EG/87/14/NMA

Application for a non-material amendment following a grant of planning permission.

Application for a non-material amendment following a grant of planning EG/29/14/HH for change from hip to gable roof structure.

Drg. no. 1420 / 03

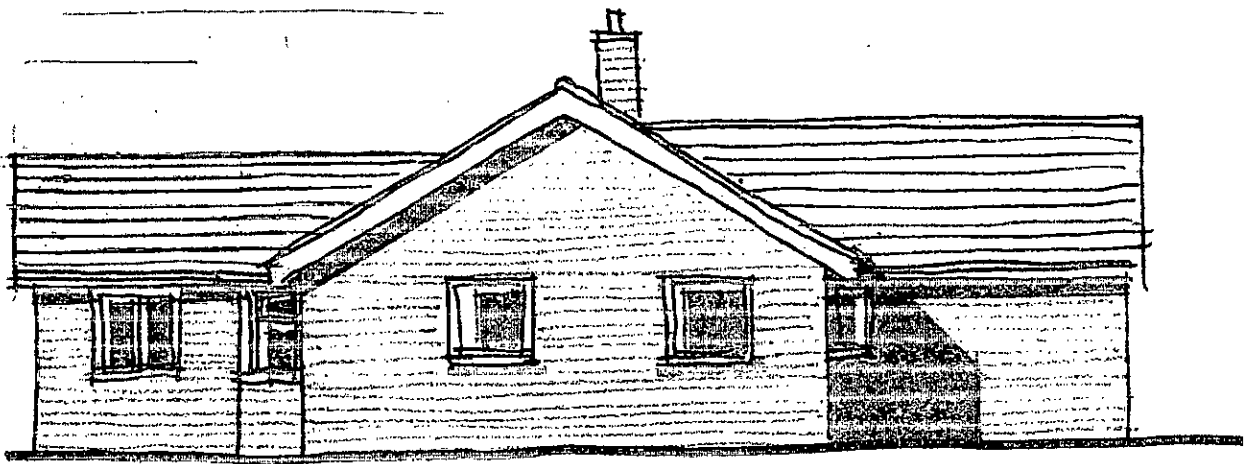
CHANGE FROM HIP TO GABLE ROOF STRUCTURE  
BECAUSE OF IN-ACCESSABILITY OF ROOF TILES (DELTA) FOR THE HIP.

DIFFICULTY OF CUTTING DELTA TILES INTO HIP - NO RIDGE TILES AVAILABLE  
FOR THIS TILE. WOULD CONFORM TO THE OTHER BUNGALOWS IN  
ROW.
